From: Emmett, Rachel - 11414 [Rachel.Emmett@lancashire.pnn.police.uk]
Sent: 08 February 2013 10:25
To: planning
Subject: Planning Application 3/2013/0084 [NOT PROTECTIVELY MARKED]
Attachments: St. Marys reception classroom Osbaldeston Re-submission.docx
NOT PROTECTIVELY MARKED

29th October 2012

Planning Ref 3/2012/0927

Title.
SCHEME 4
PROPOSED PLAN & ELEVATIONS

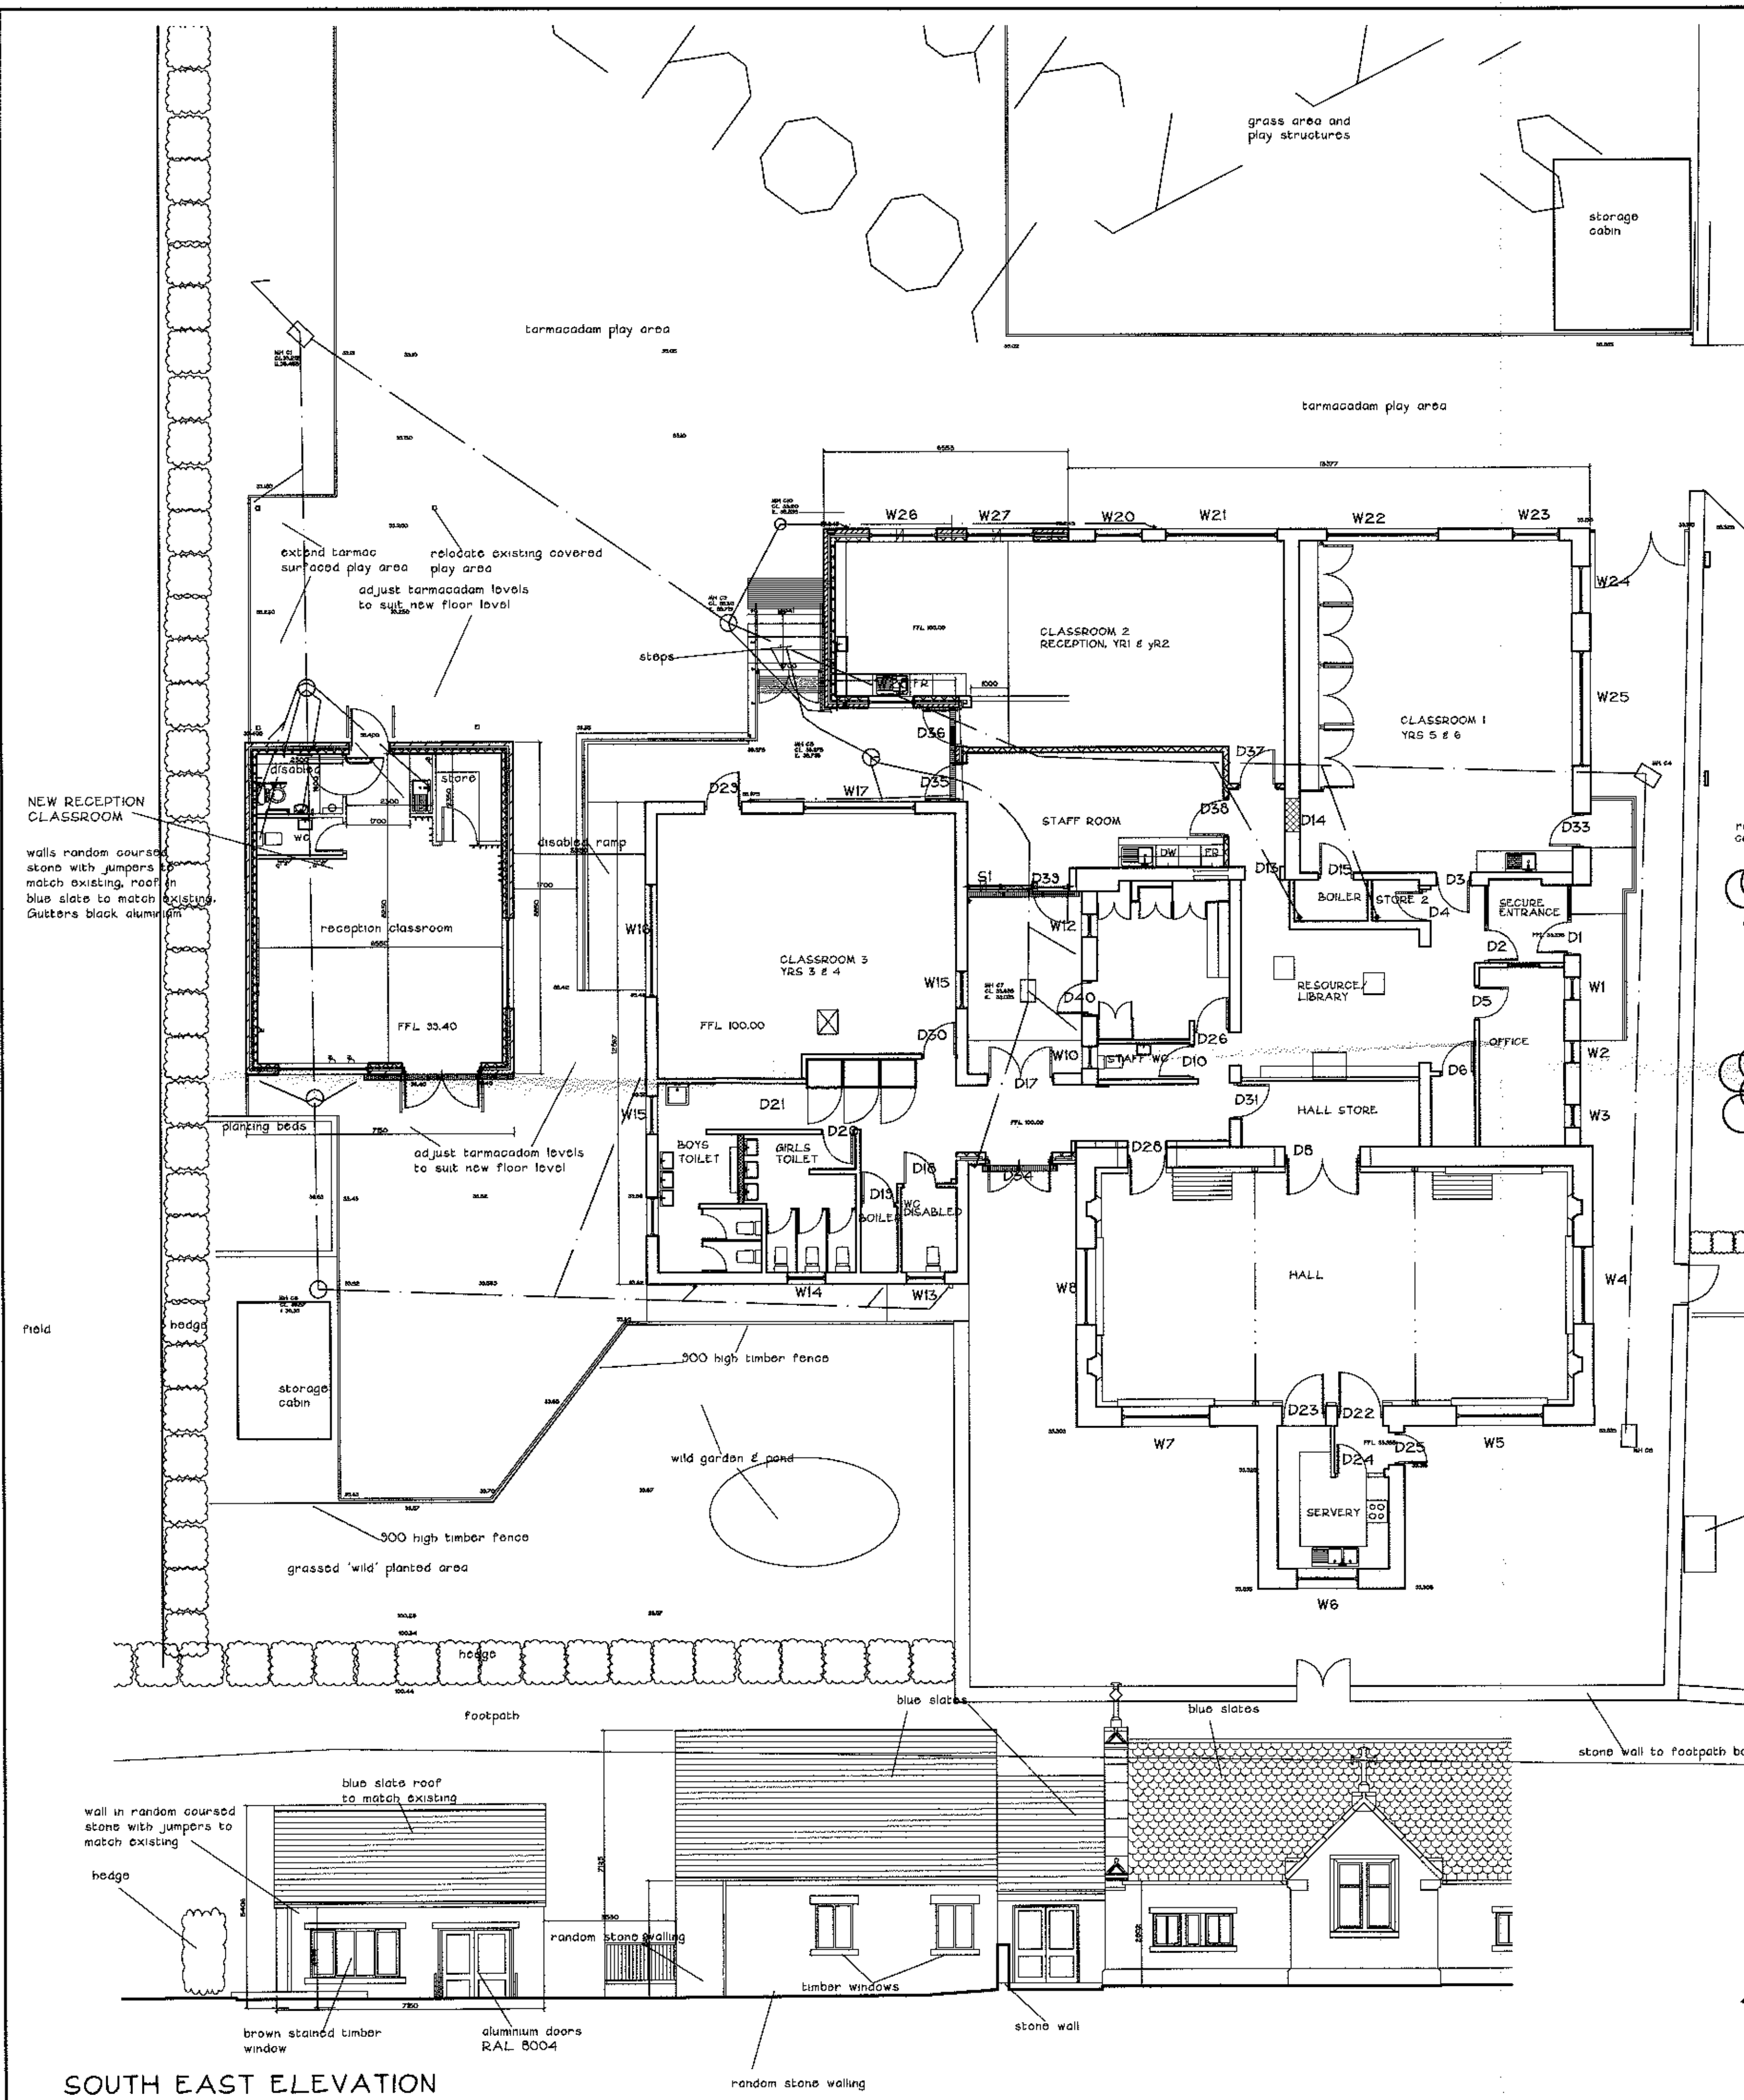
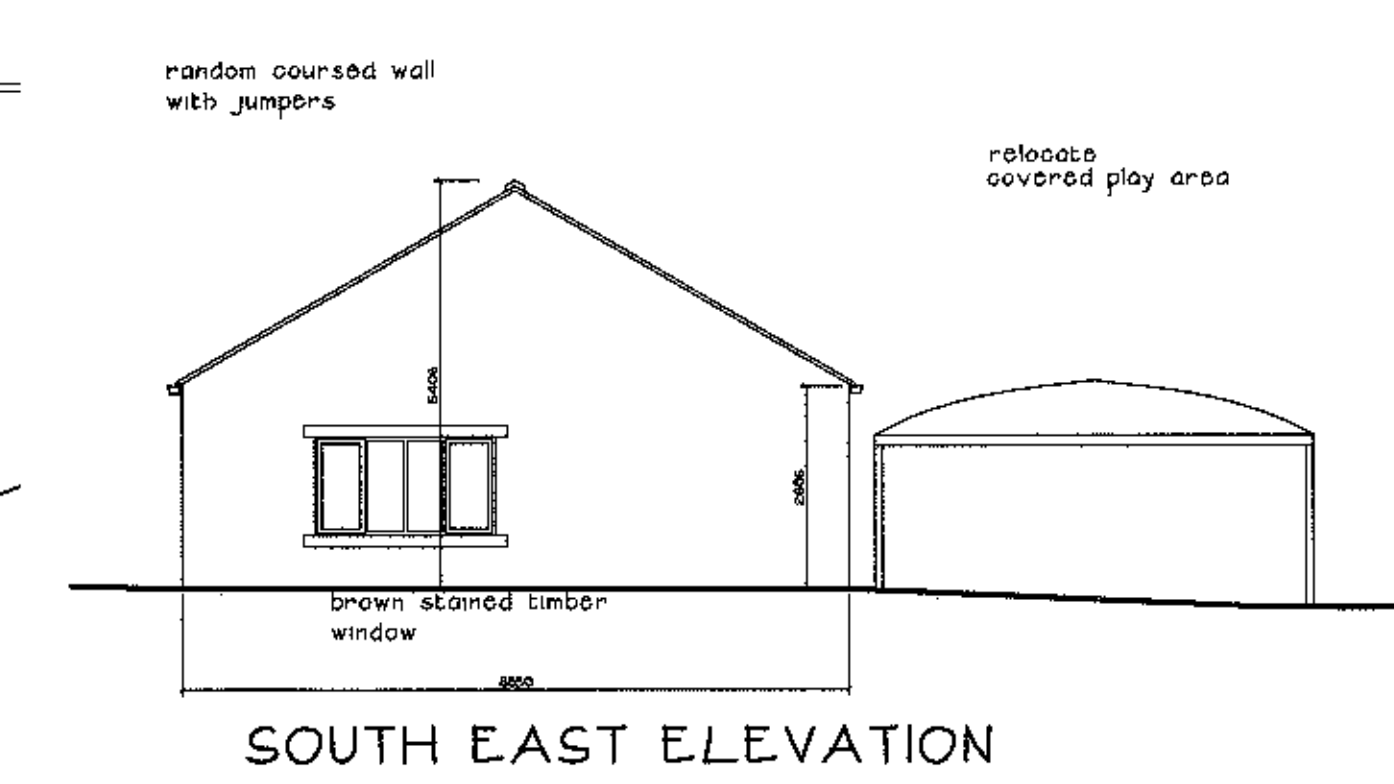
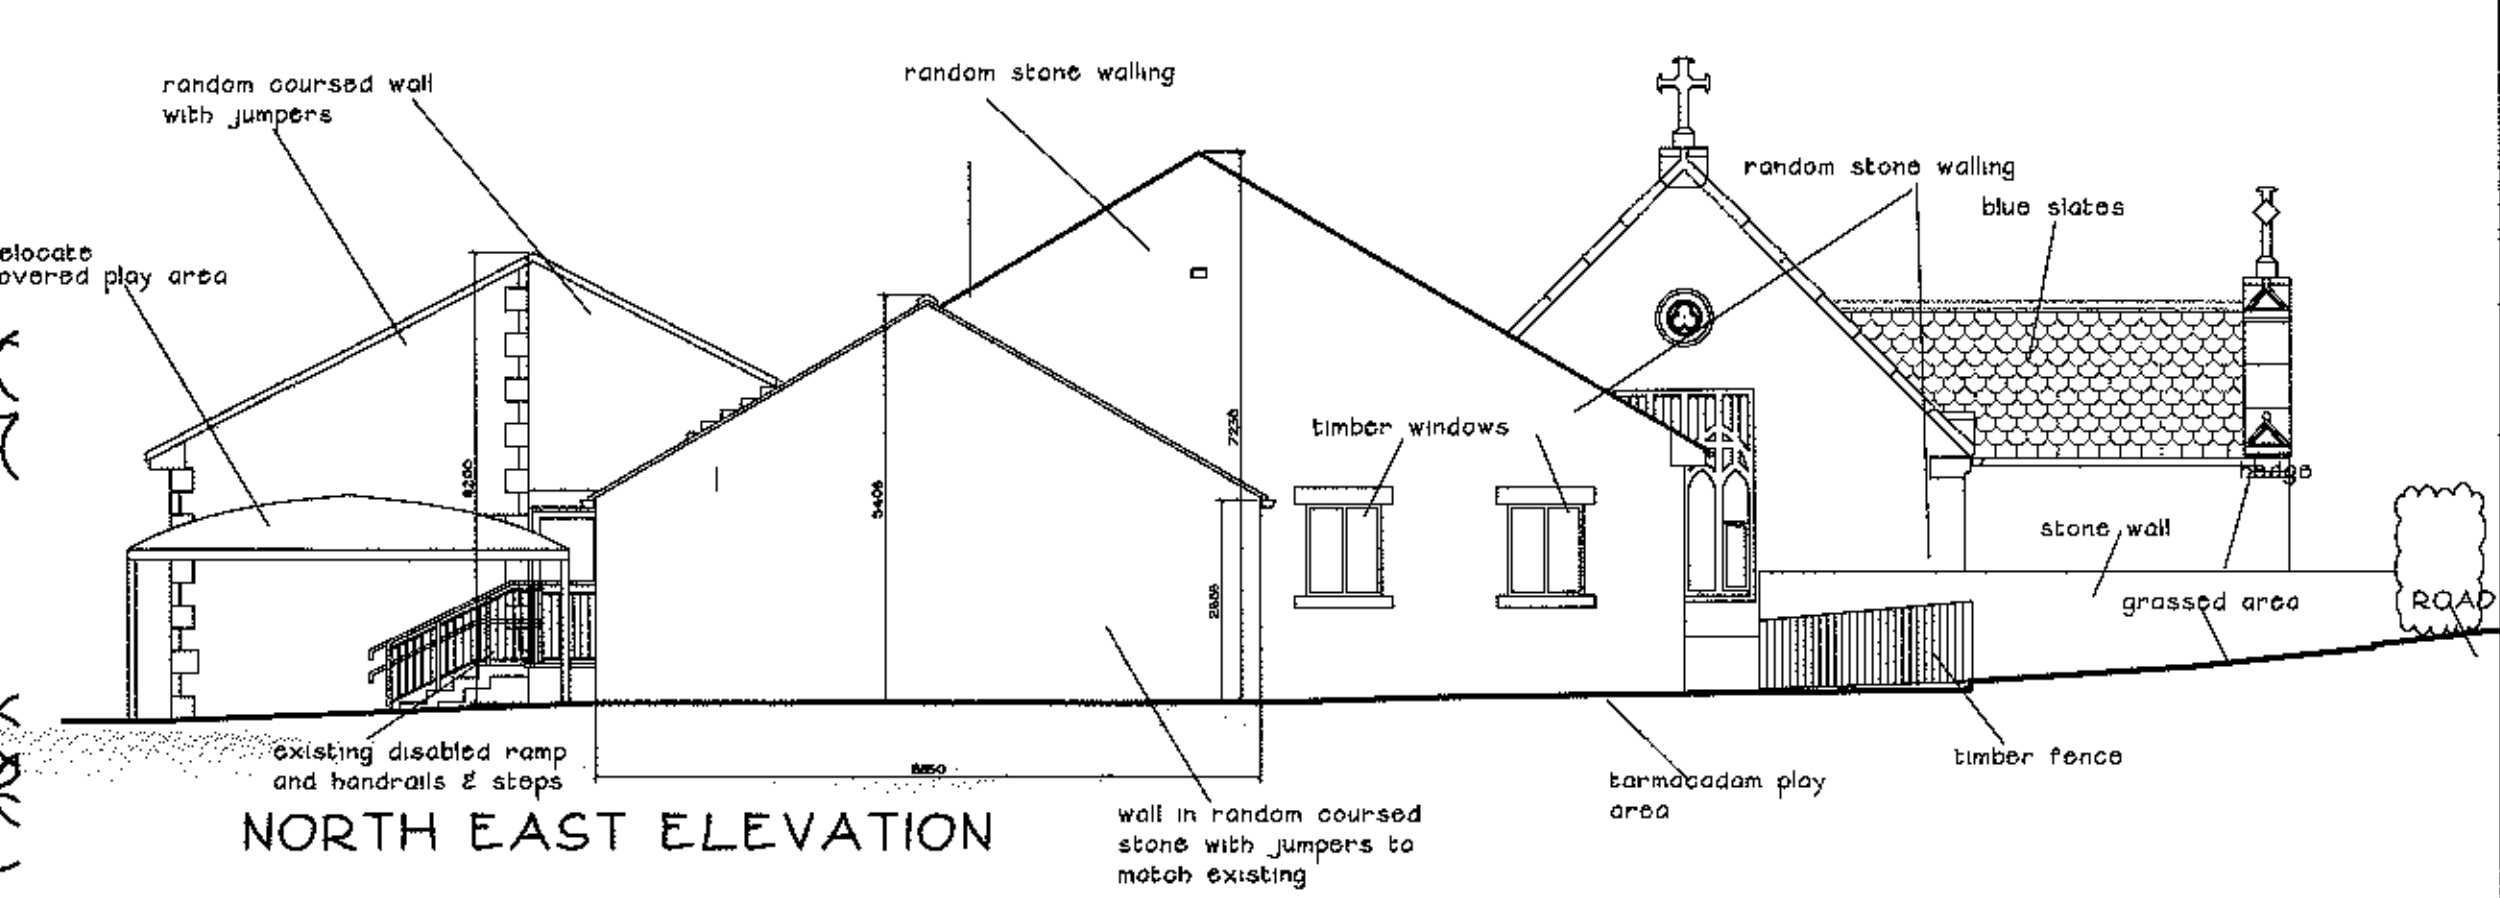
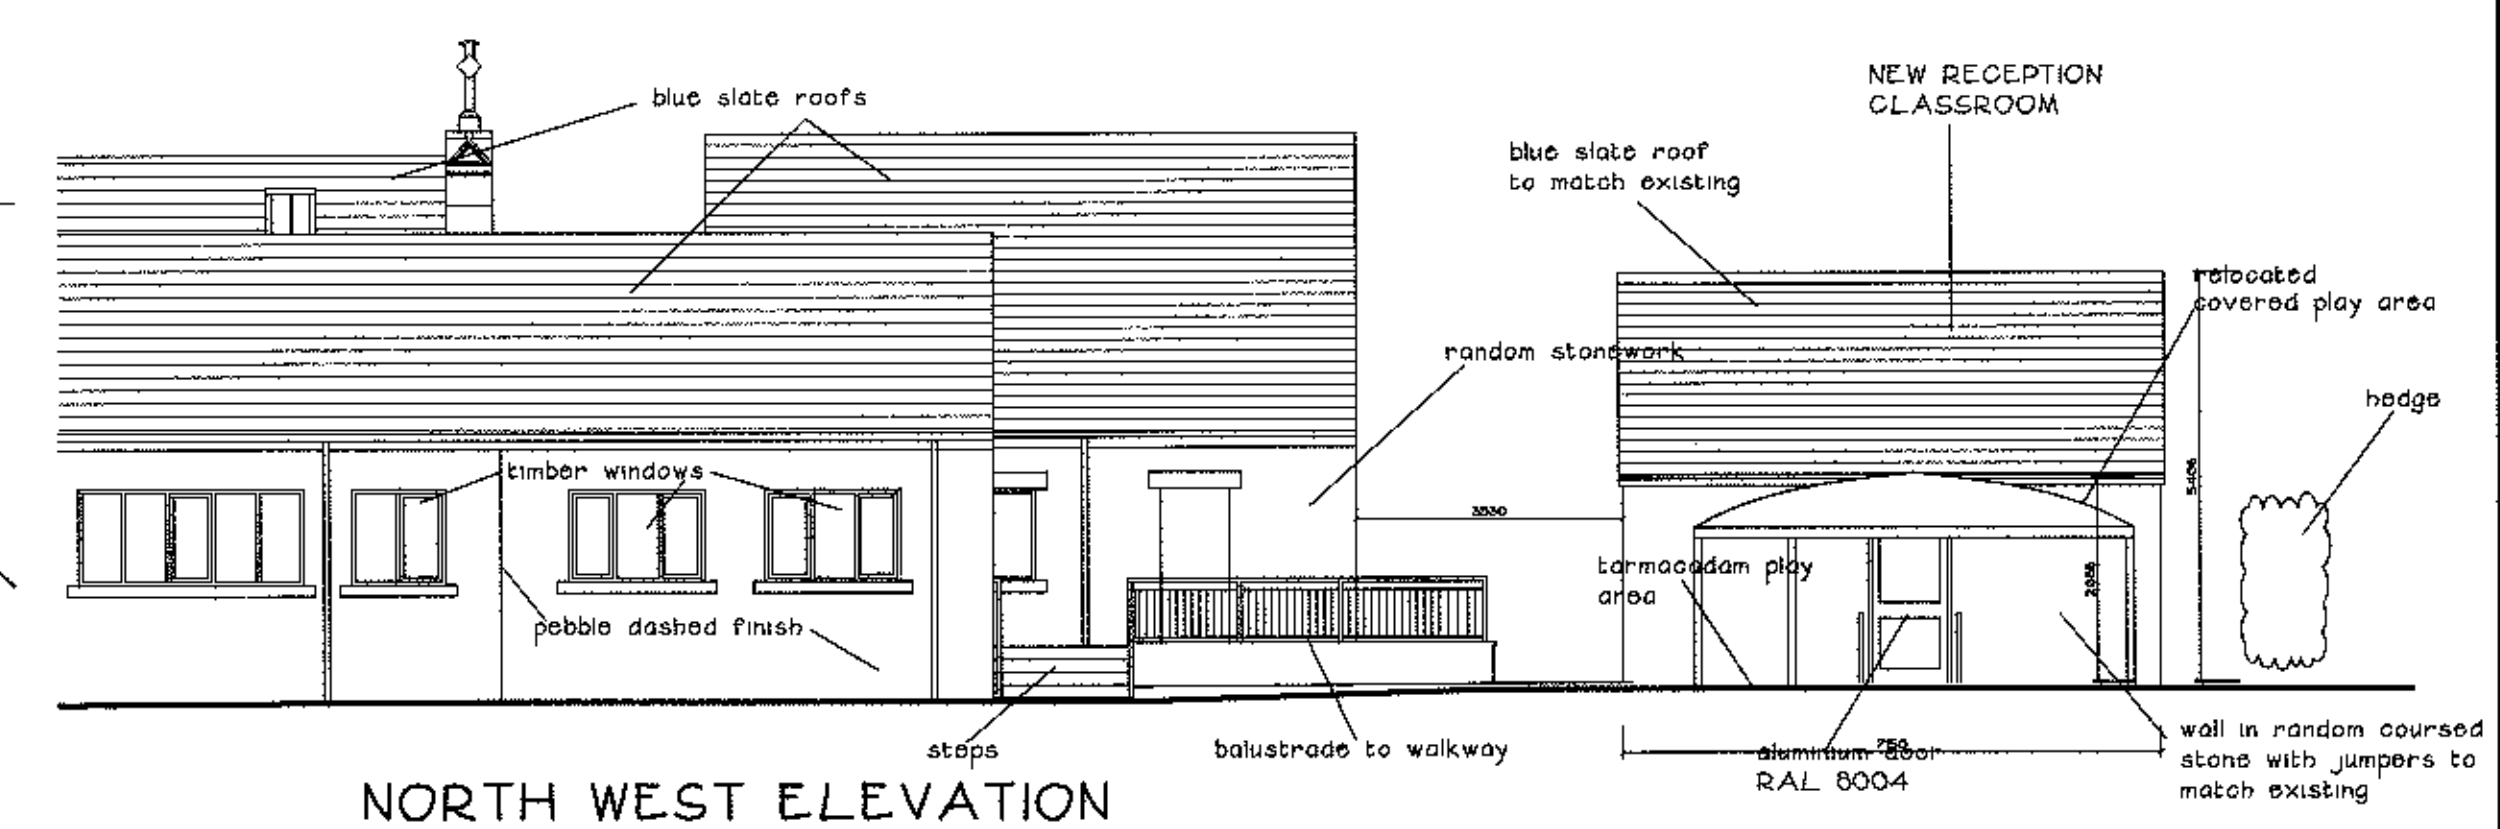
The security of the site is not referred to in the application but I feel it should be thought about at this early stage to ensure the right products are incorporated within the design to safeguard against future crime.

As this building is not part of the main school building, consideration should be given as to how the alarm system would link up to the main school alarm. The windows should meet British Standard 7950, should be laminated or toughened glazing and be fitted with restrictors which prevent them being opened beyond a small amount from the outside.

The external door sets should meet PAS 24, this means that it has been tested against regular forms of intruder attack.

Electronic access control should be considered to prevent unauthorised access.

If the site currently has a CCTV system, it should be extended to cover the new building.

Internal storage should be considered for locking away valuables, out of sight – not seen from windows and doors.
